Appendix III: Pre- application Response16/02142/PREAPP

**RE: Conversion of offices to residential. Conversion of nursing home to residential.
New Build lodge and associated landscaping and parking -total units 16**

SITE: Manor Farm High Street Hamondsworth

First Floor Plan

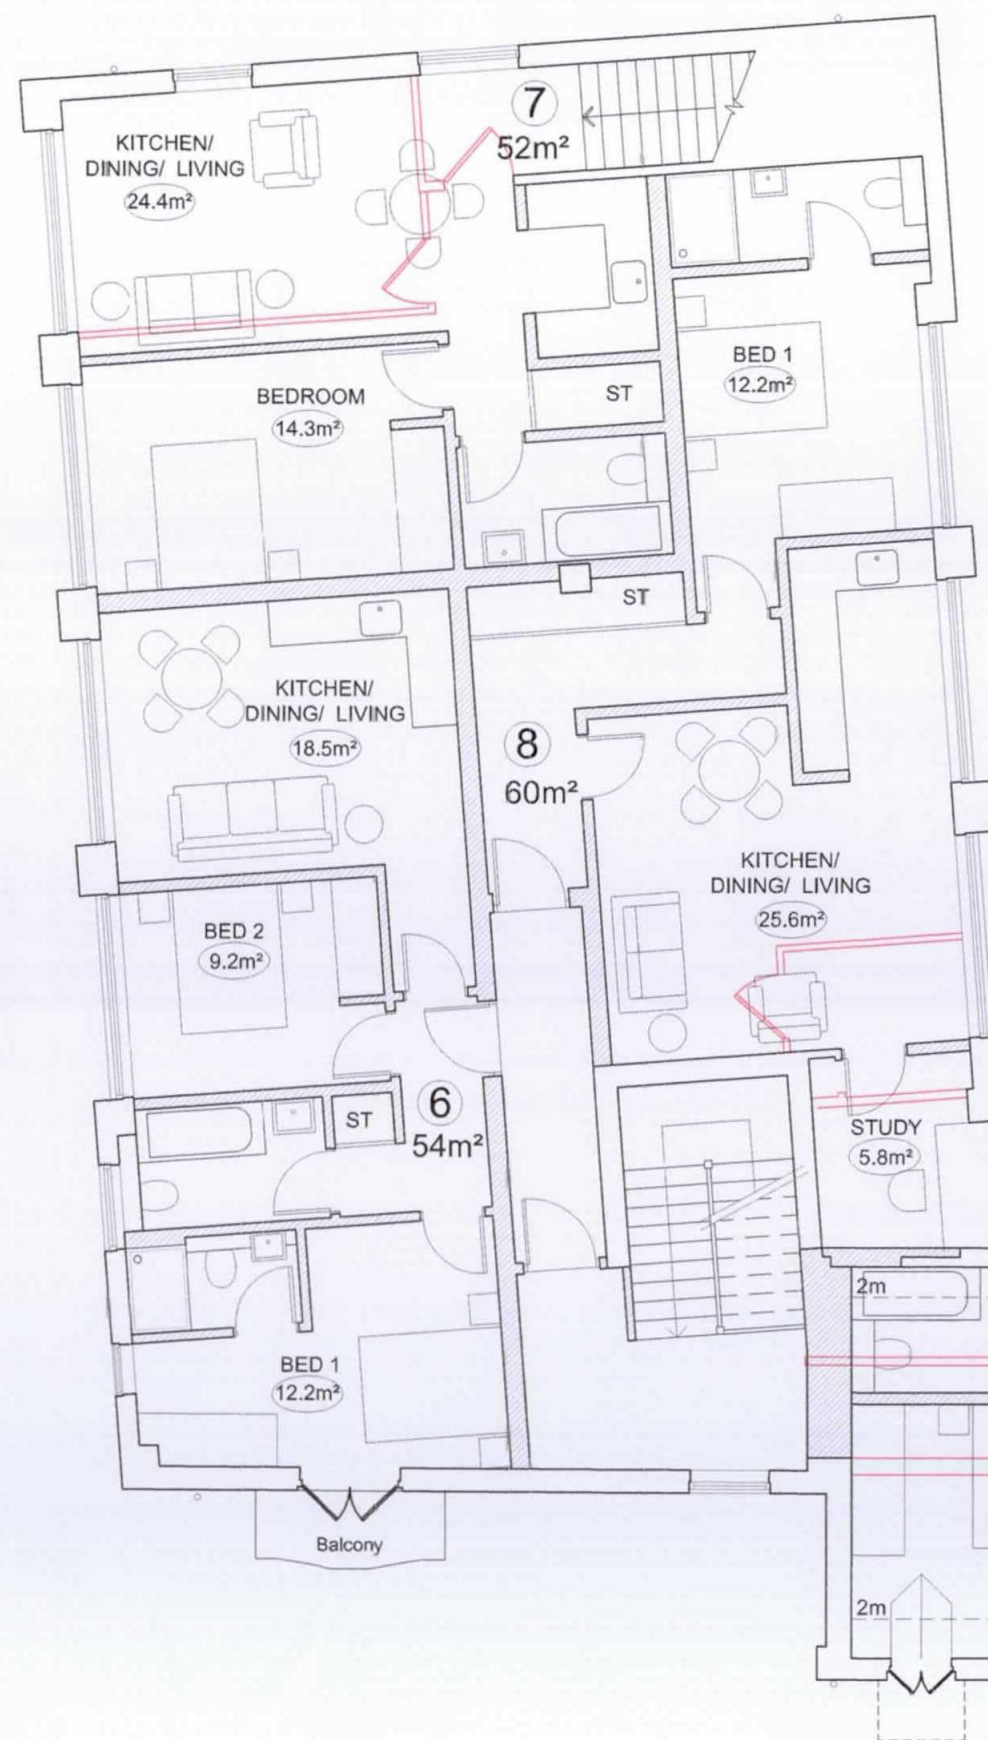
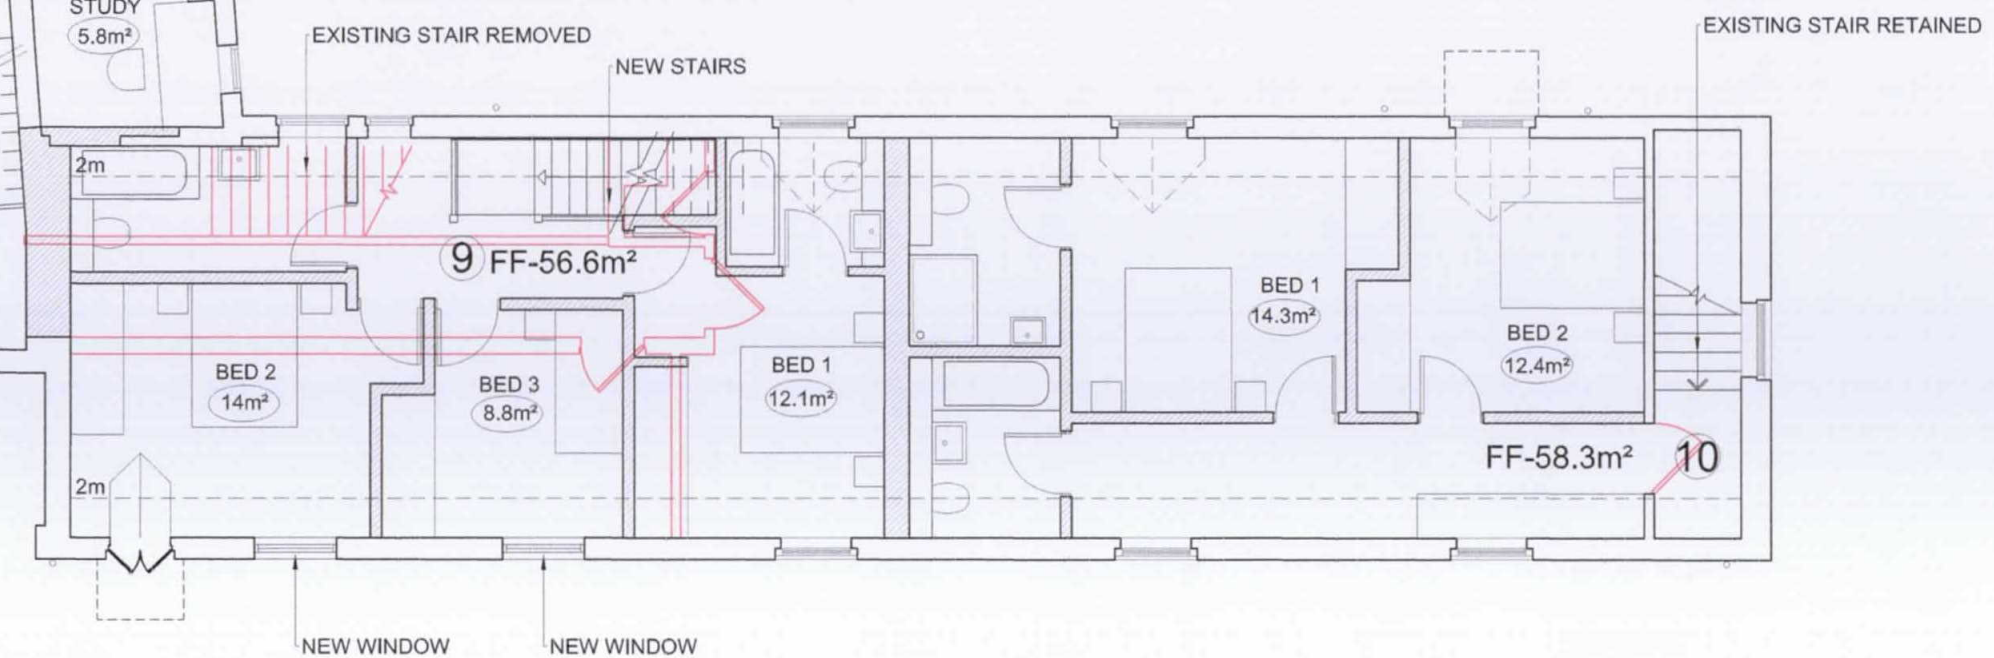
The glazed door on elevation 4 would be better designed as a traditional half stable door to avoid what looks like a hole in the elevation. There also appears to be an extra window at first floor front on the floor plans, which should be avoided.

EXISTING Elevation 3

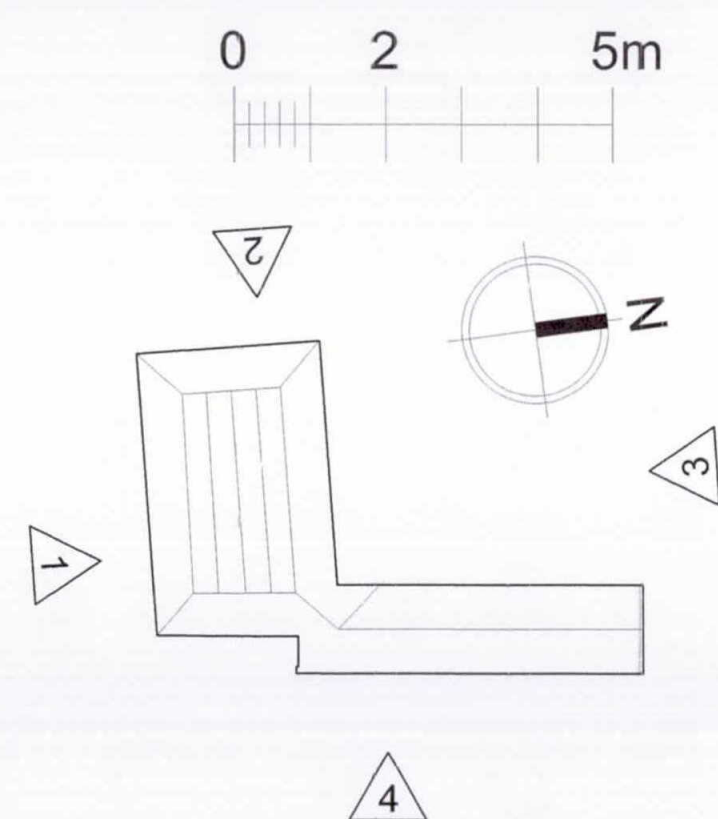
linked seamlessly with the existing structure. Ideally, the ridge line should be dropped on the first floor addition, to retain the step in scale that exists across elevation 1. The inserted windows to side elevation 3 are too large.
